Recommendation Report for Planning Permission

REF NO: M/61/14/PL

LOCATION: The Litten
Ancton Lodge Lane
Bognor Regis

PROPOSAL: Extension and conversion of existing residence into 3 No new flats & replaced and repositioned garage (resubmission following M/13/14/).

b			
a			
Amendments		by	Date
Job Title			
Ref 097			
Ancton Lodge			
Drawing			
Proposed Floor Plans/Elevations			
Scale: 1:100 @ A1			
Drg.No.	ADS-004	*	
Drawn by	NJH		
Status:	Planning		
Date	24.07.14

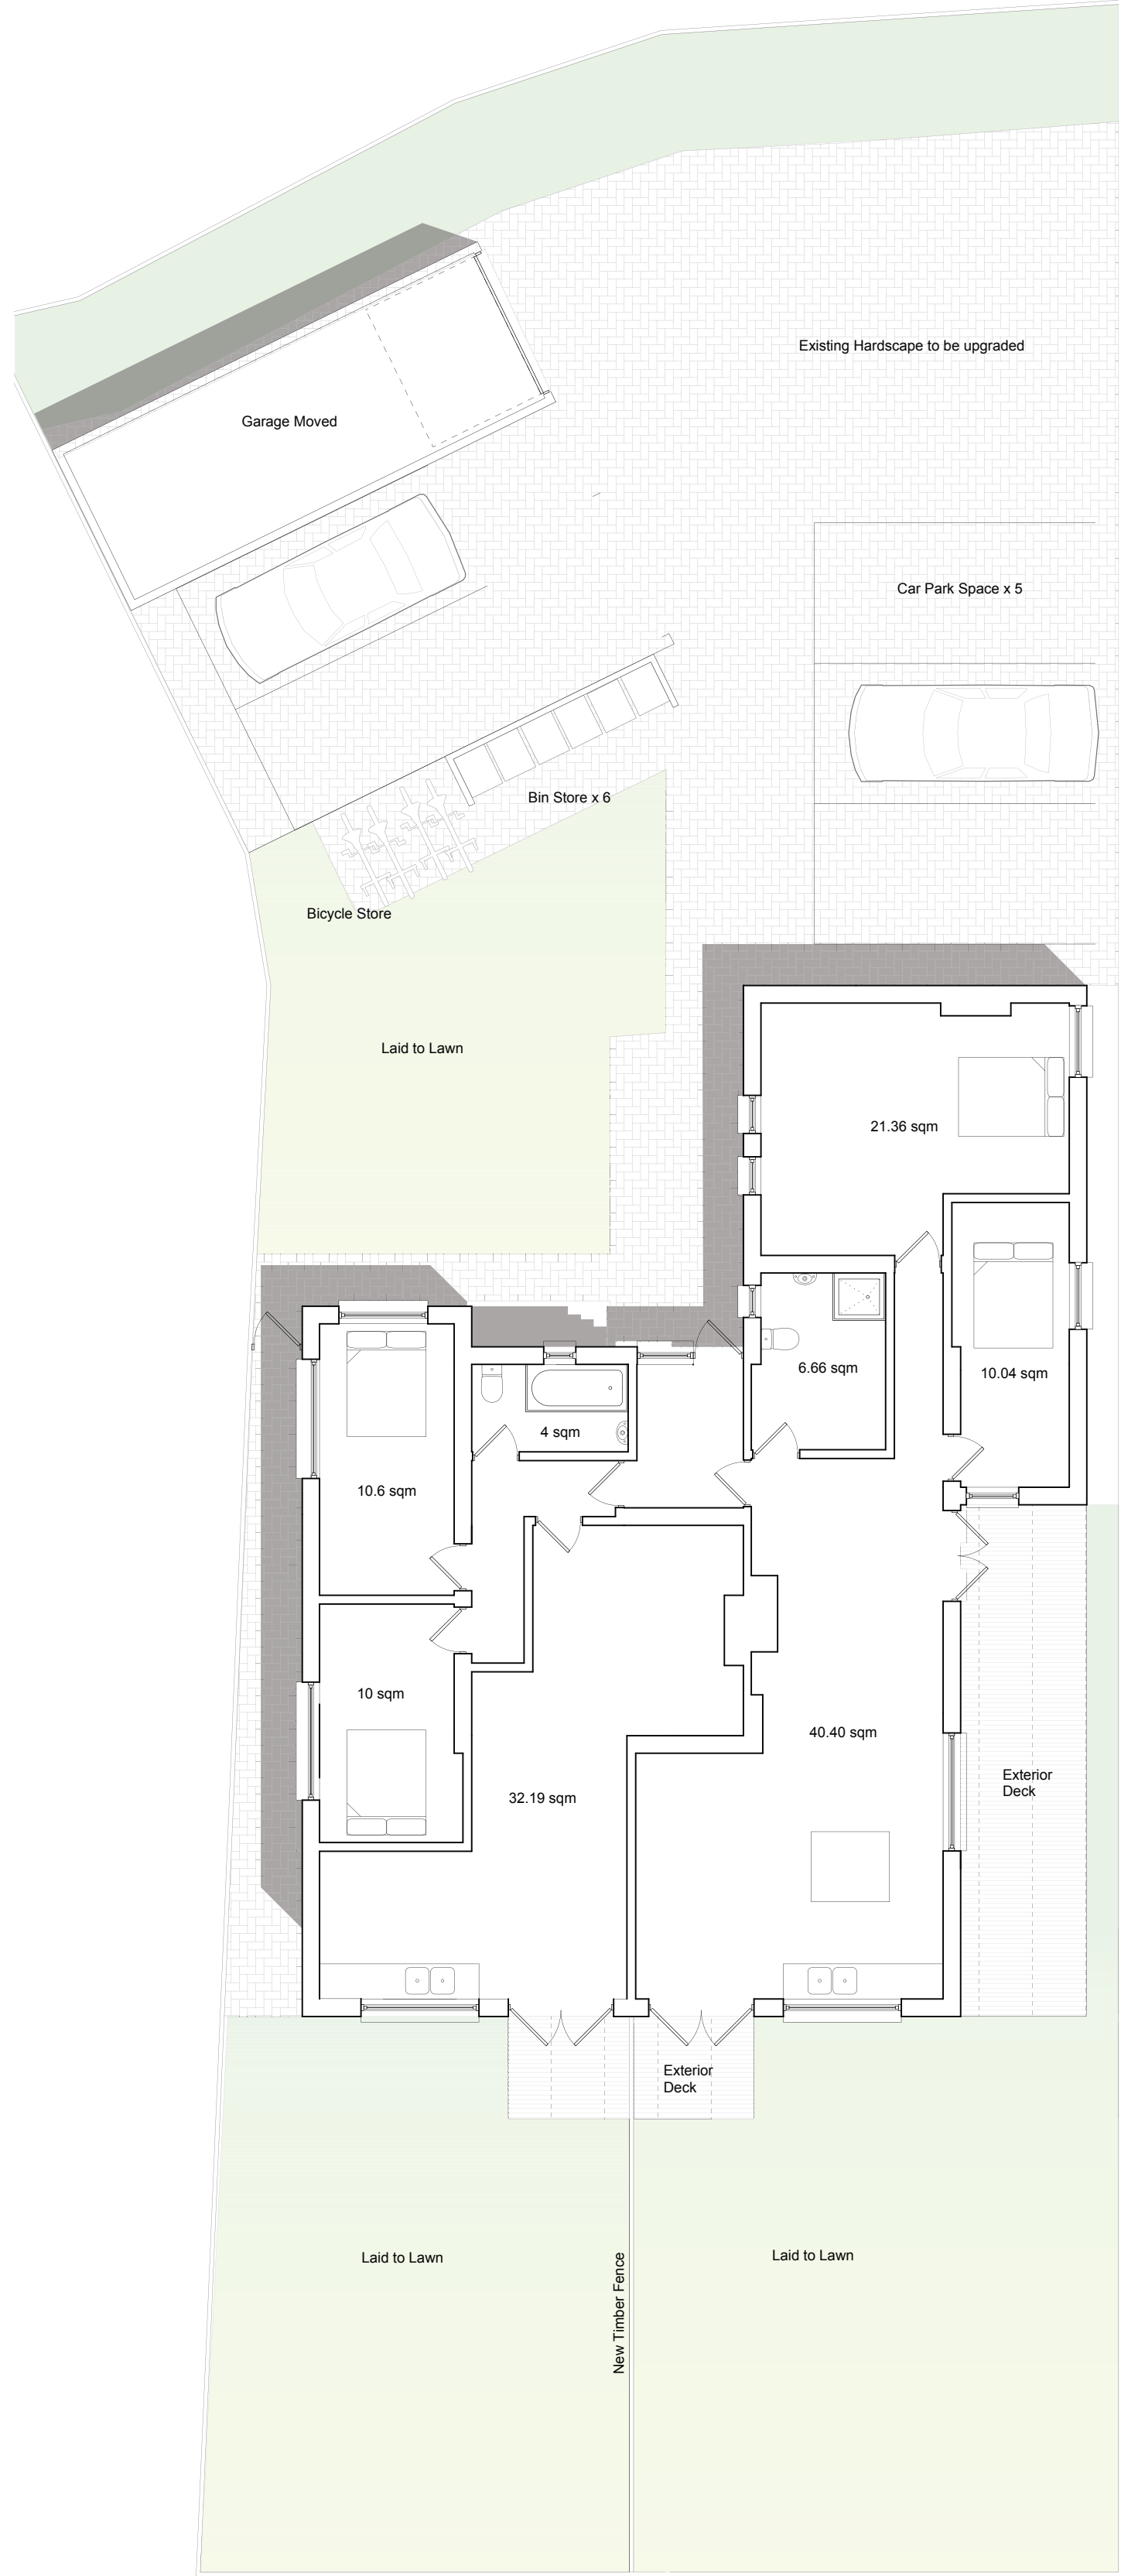
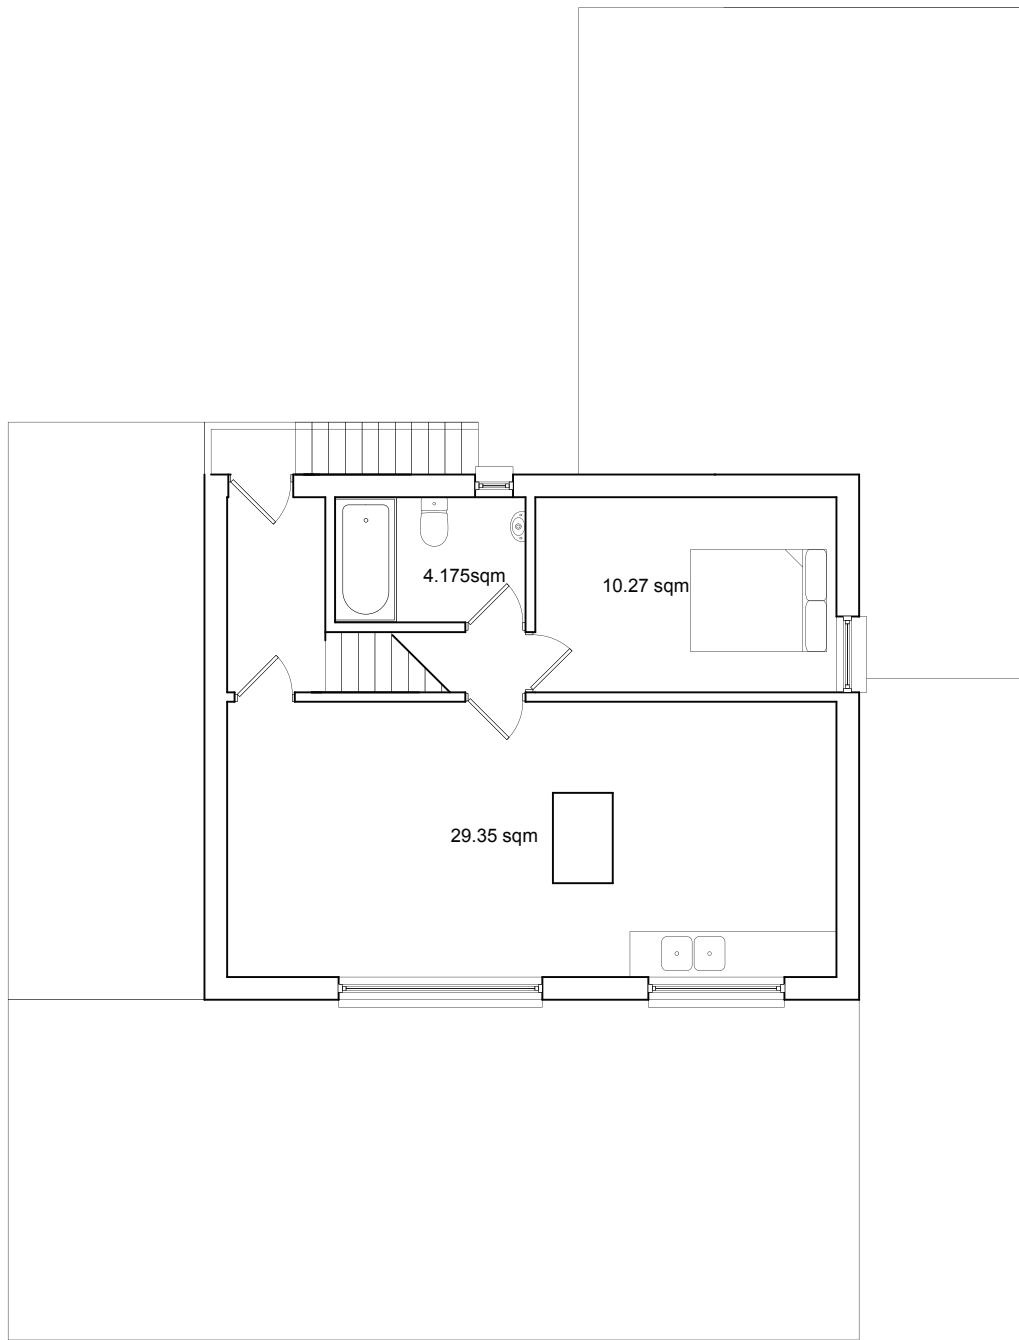
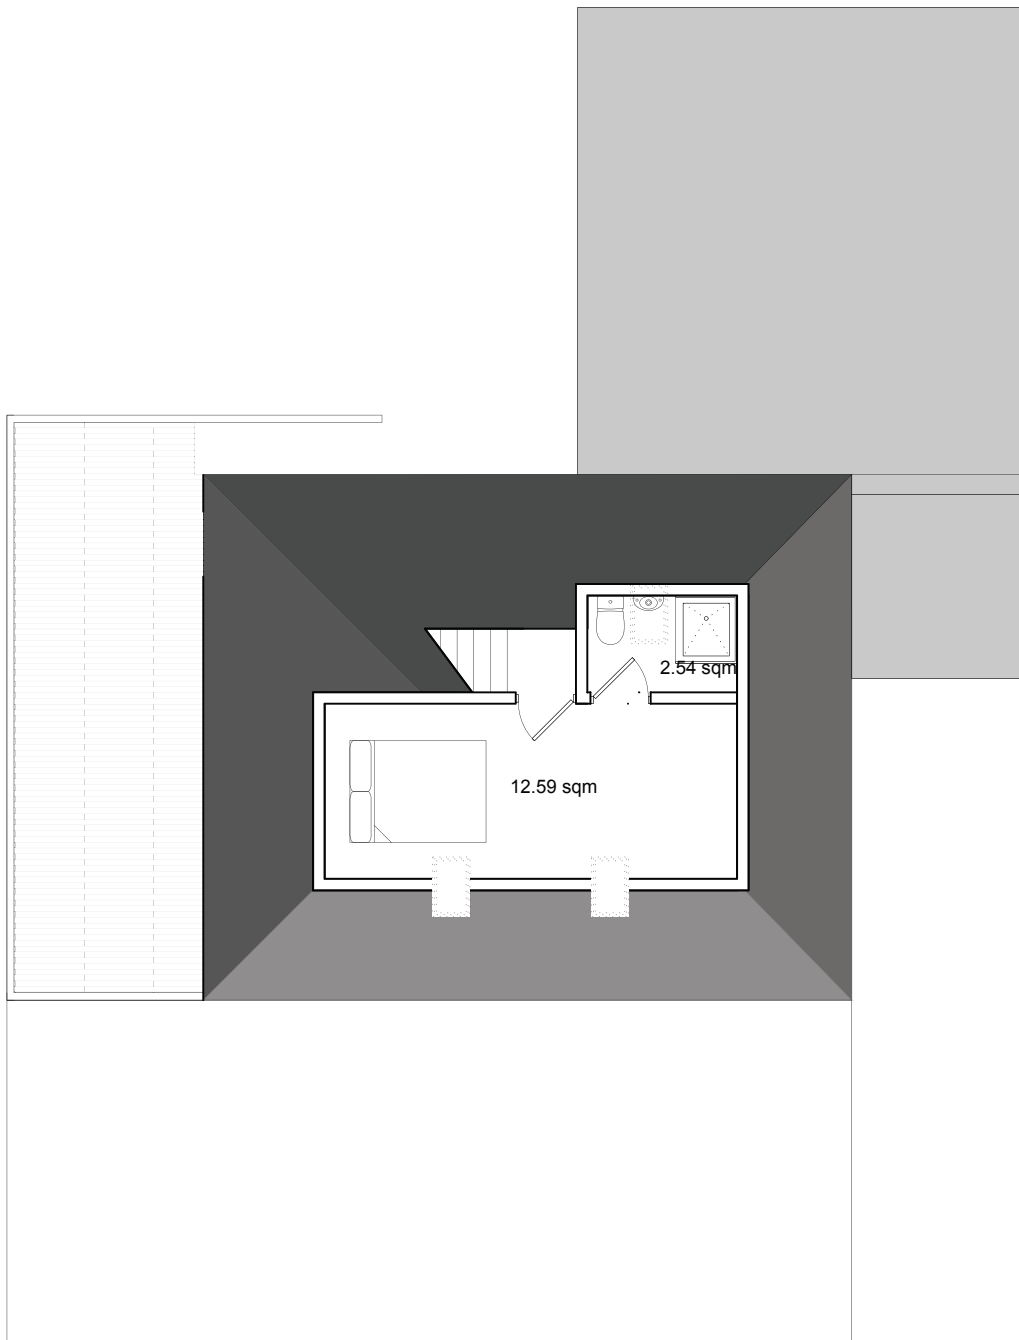
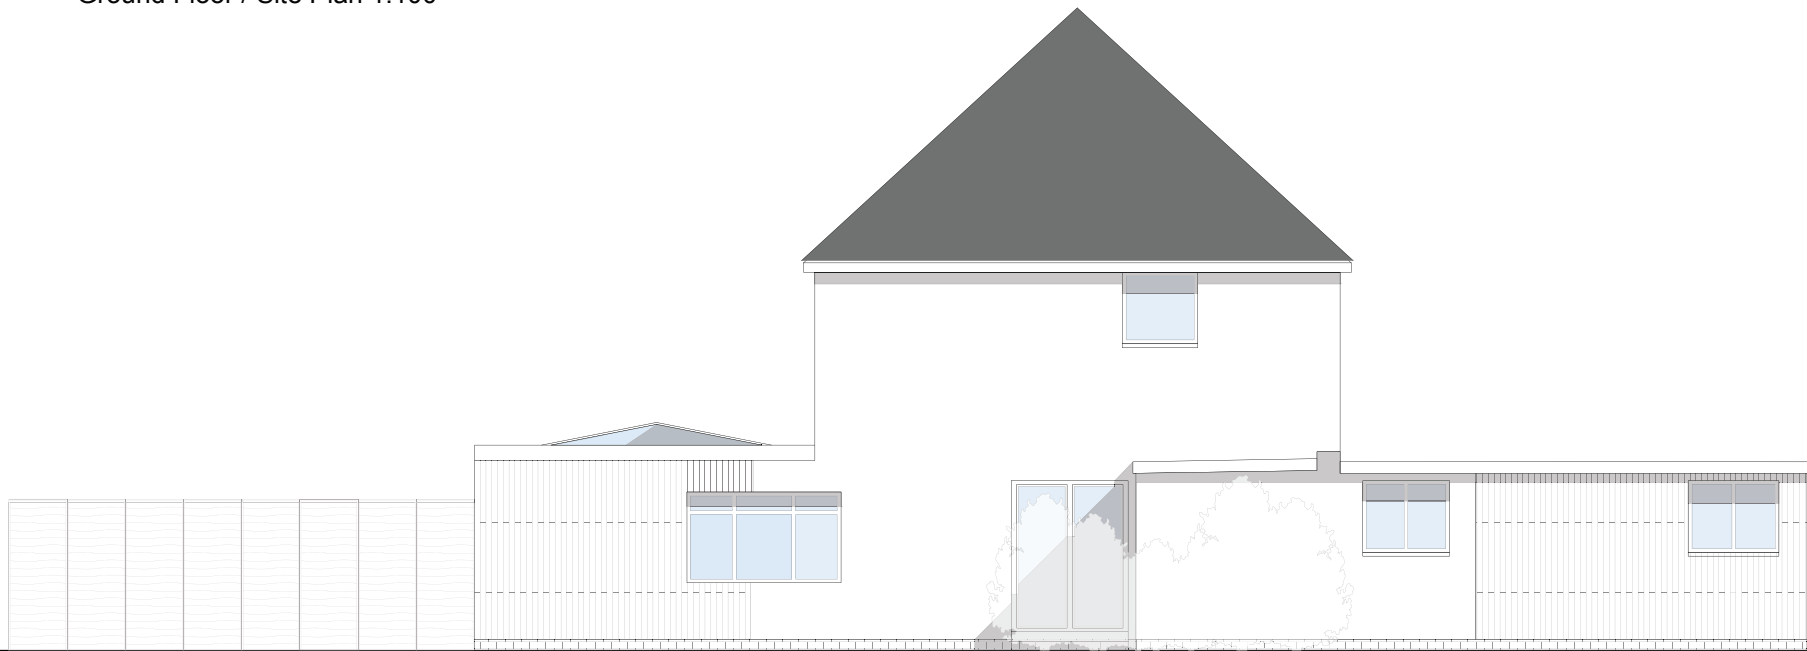
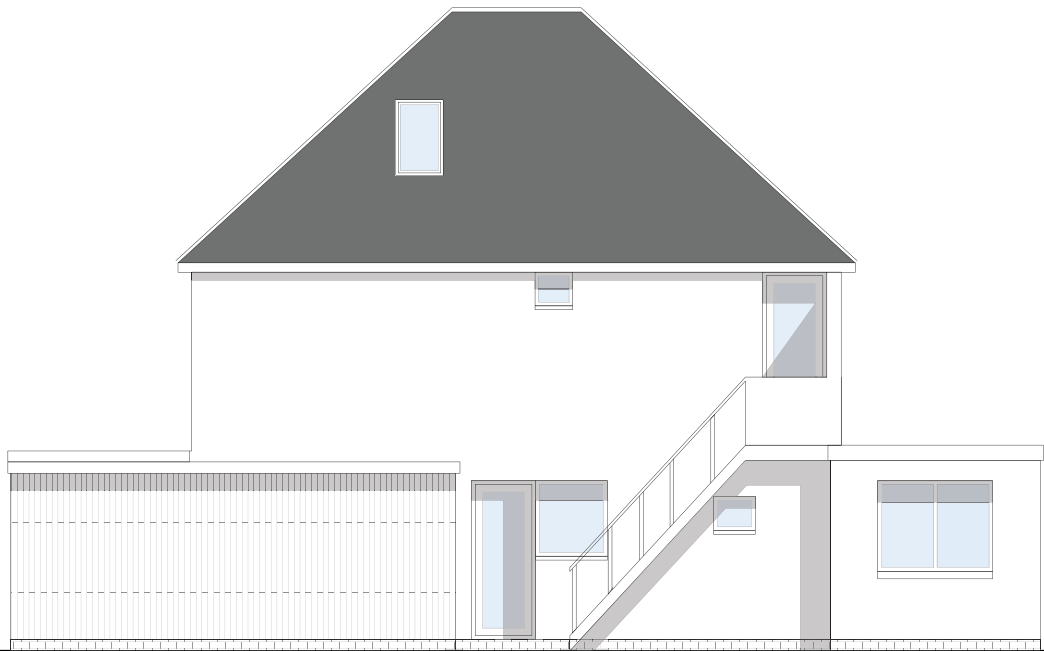
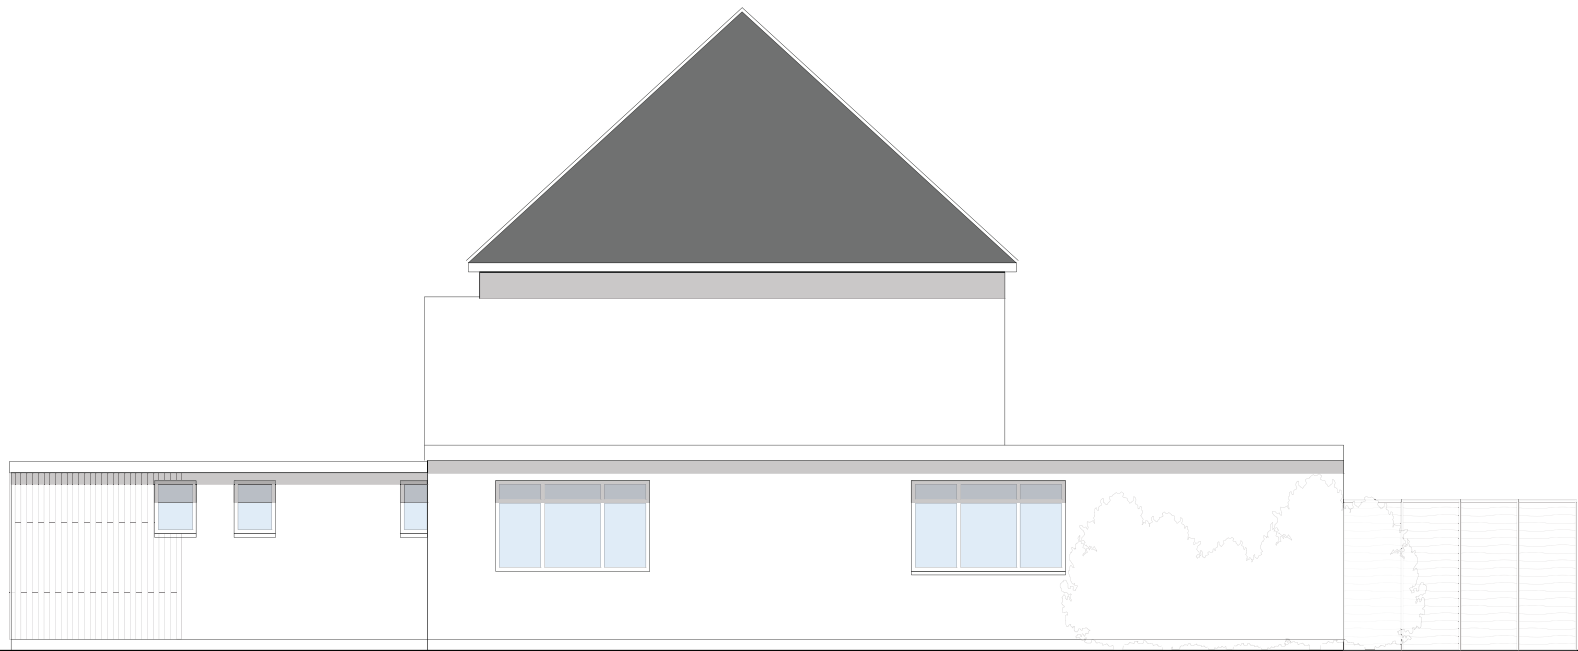
As above. The proposal relates to the conversion and extension of the existing property to create 3 2 bedroom flats. 2 are located on the ground floor and the other is located on the first floor with a bedroom in the roof. The extensions would be single storey and measure 1.8m by 6m on the north west corner of the building and 11m by 4.8m on the southern side of the building. They would be flat roofed with a height of 2.6m.

Environmental Health - No Objection. Fire resistant glazing will be required to windows on the north elevation.

The existing dwelling is close to the site frontage and the extension to the west would not be readily visible in the street scene being located behind the property. The extension to the south would be single storey and 2.5m from the site frontage. It would be subservient in height and design and would not detract from the appearance of the dwelling which already has other single storey extensions which are also flat roofed. The proposal also removes an unneighbourly balcony on the west elevation which causes adverse overlooking and loss of privacy to the adjacent residential dwelling. The flat roofed extension would be 1m from the rear boundary and would be located behind 2m high close boarded fencing. It would not project significantly above this boundary demarcation and would not be overbearing on the property to the north given its flat roofed design. The extensions are therefore acceptable in terms of their impact on the visual amenities of the locality and the character of the area.

The overall internal floor areas of the flats accord with those for a single storey 2 bedroom, 3 person flat (albeit the upper flat extends into the roof area). The bedrooms to one of the ground floor units is undersized, whilst the other is larger than is necessary for a second bedroom. Environmental Health have no objection to the proposal on the grounds of room size and the proposal is therefore considered acceptable in relation to the proposed room sizes.
